Planning reference LU/177/14/PL
Proposed residential development at
The Old Dairy, Church Street, Littlehampton.

Further to my recent conversation with you regarding the above development, and to my previous objection dated the 3rd December 2013, I wish to raise further objections to the revised planning application as follows :-

SITE PLAN WITH DRAFT LEVELS
 PROPOSED RESIDENTIAL DEVELOPMENT
 THE OLD DAIRY, CHURCH STREET, LITTLEHAMPTON, SUSSEX.
 GRAHAM NICOLLS LIMITED, DESIGN + TECHNOLOGY, TEL/07990 522709

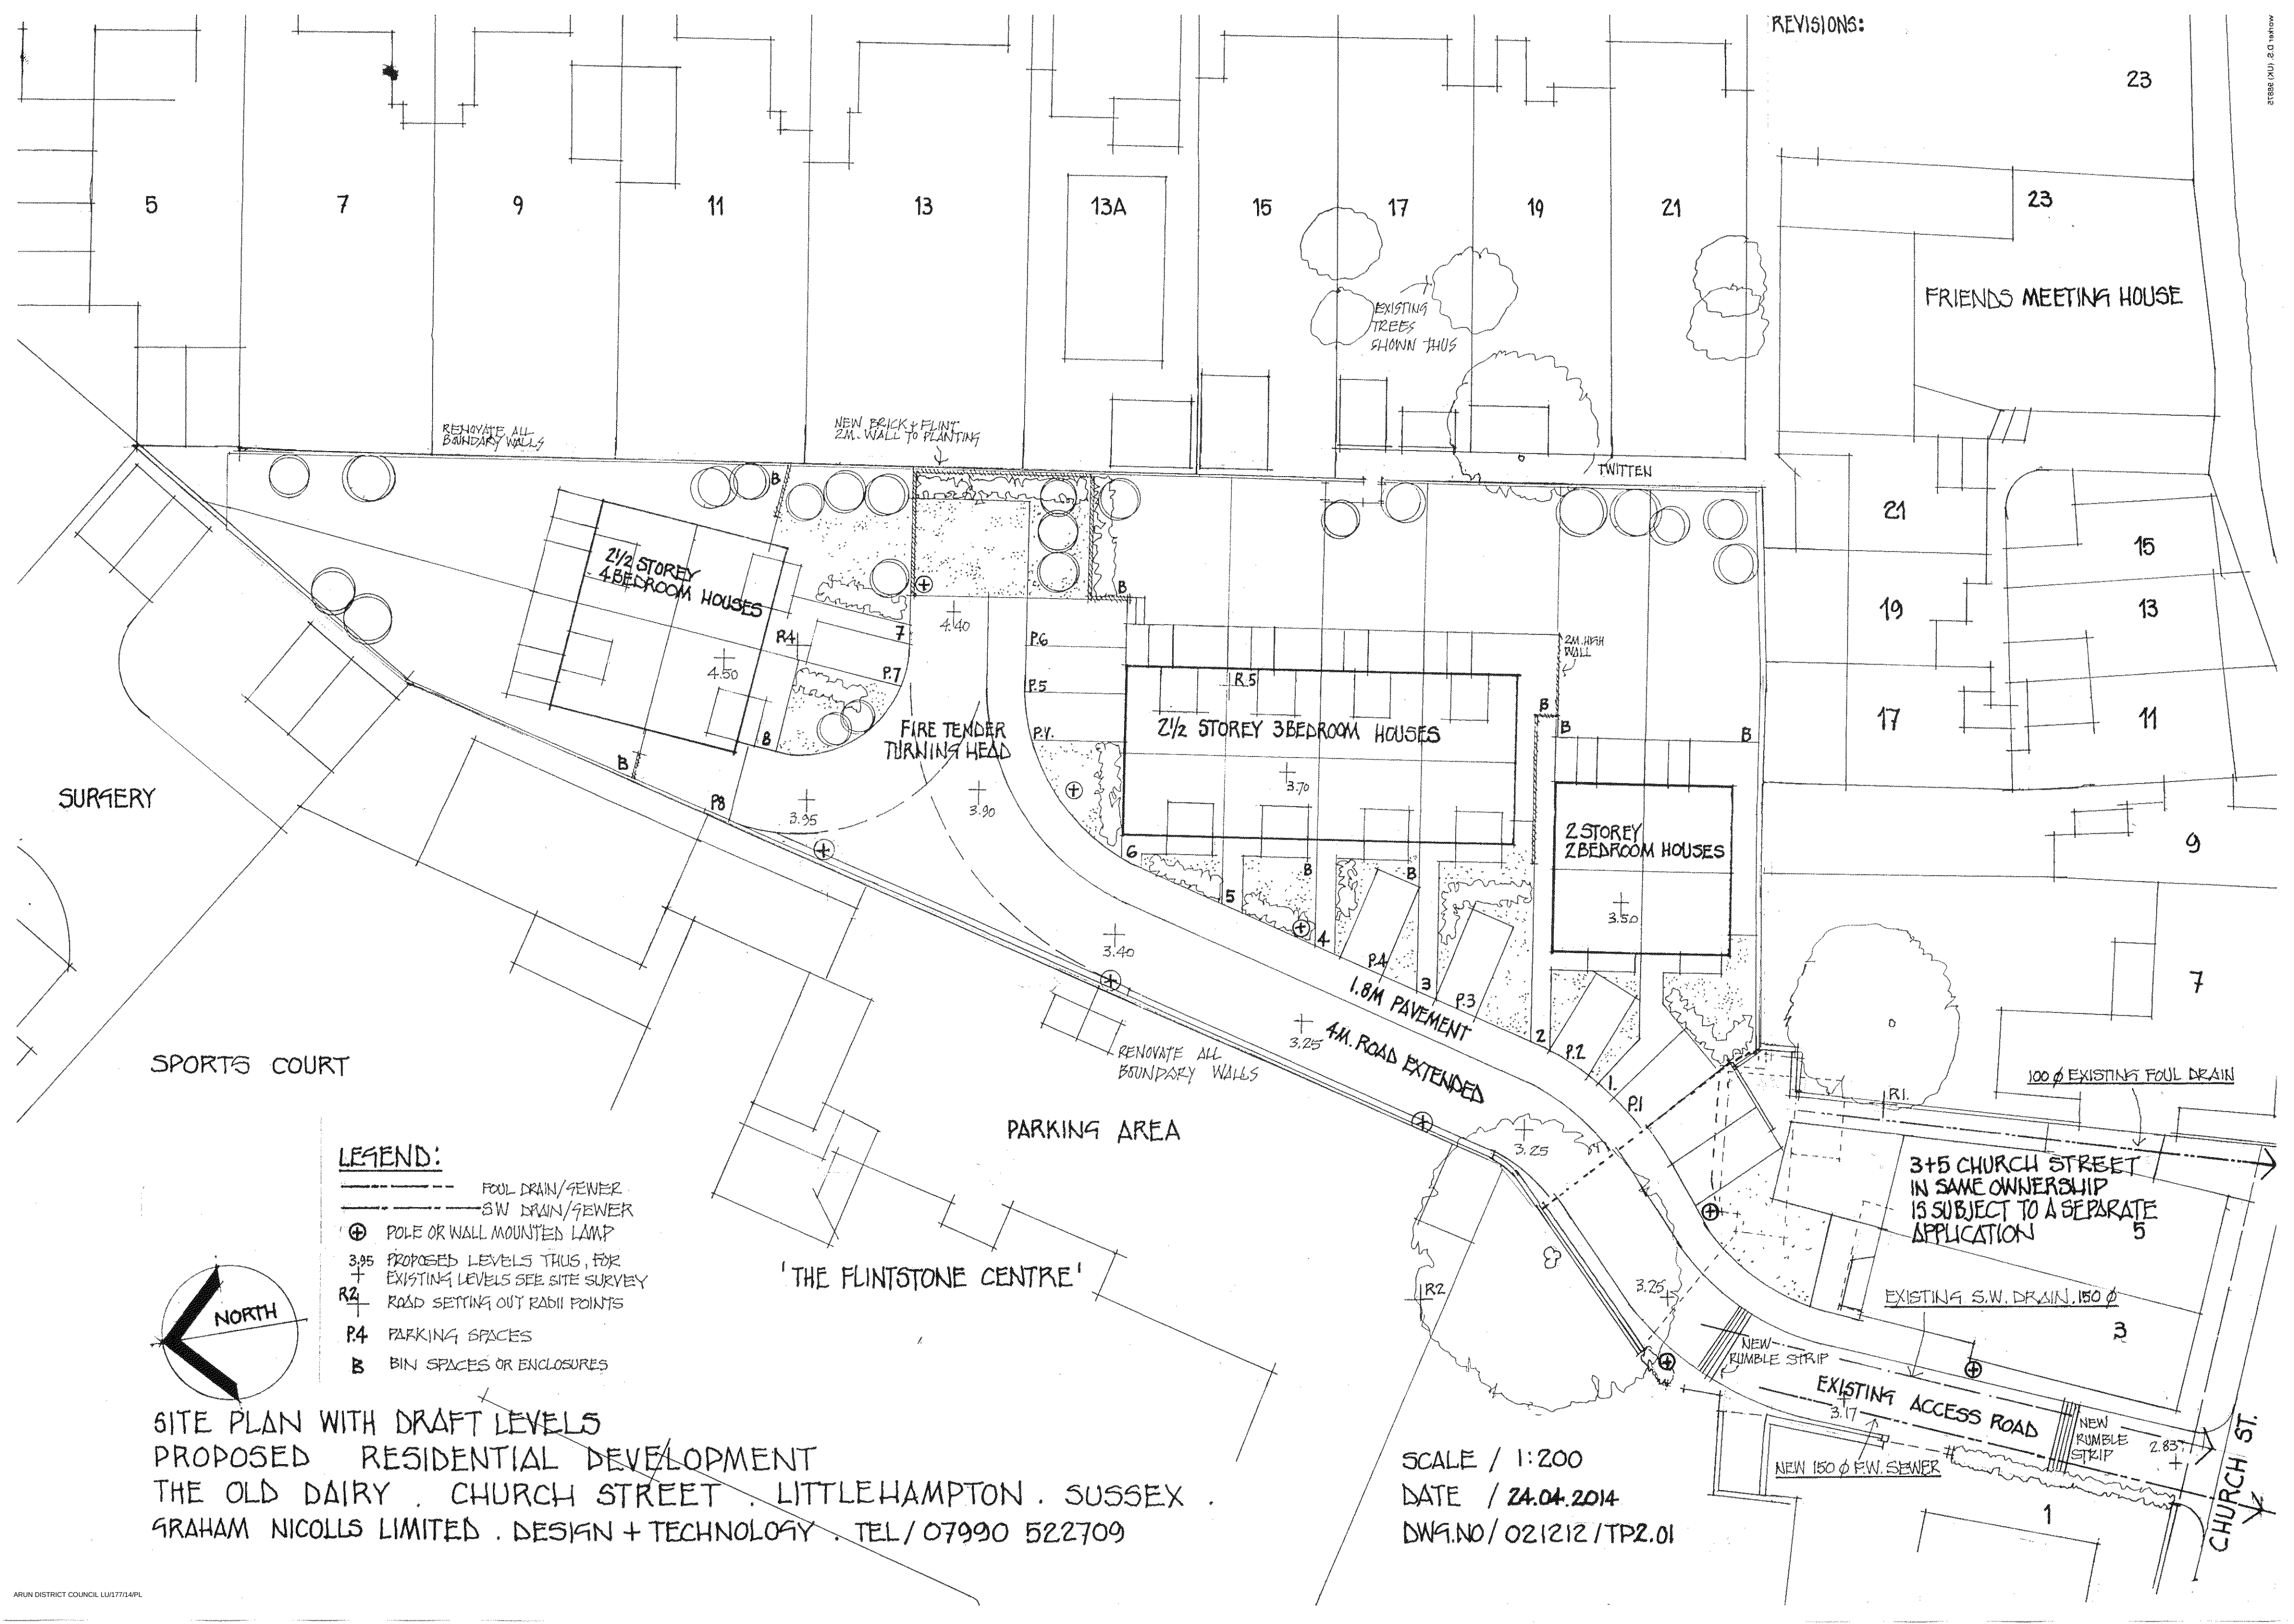
- (2) I refer also to the passage/"twitten" at the rear of Nos. 17, 19 & 21, Goda Road and South side gate of No. 15 leading into Goda Road, access to which is reserved and confined to those properties. I object strongly to such access being shown on the plans for the site to prevent any future use by the owners or occupiers of the houses to be built thereon, and to ask that the door into such passage/"twitten" which is not owned by the Developer be taken out and the wall rebuilt as before. This opening and access was not shown on the previous site plan under reference LU/298/13 edged in red.
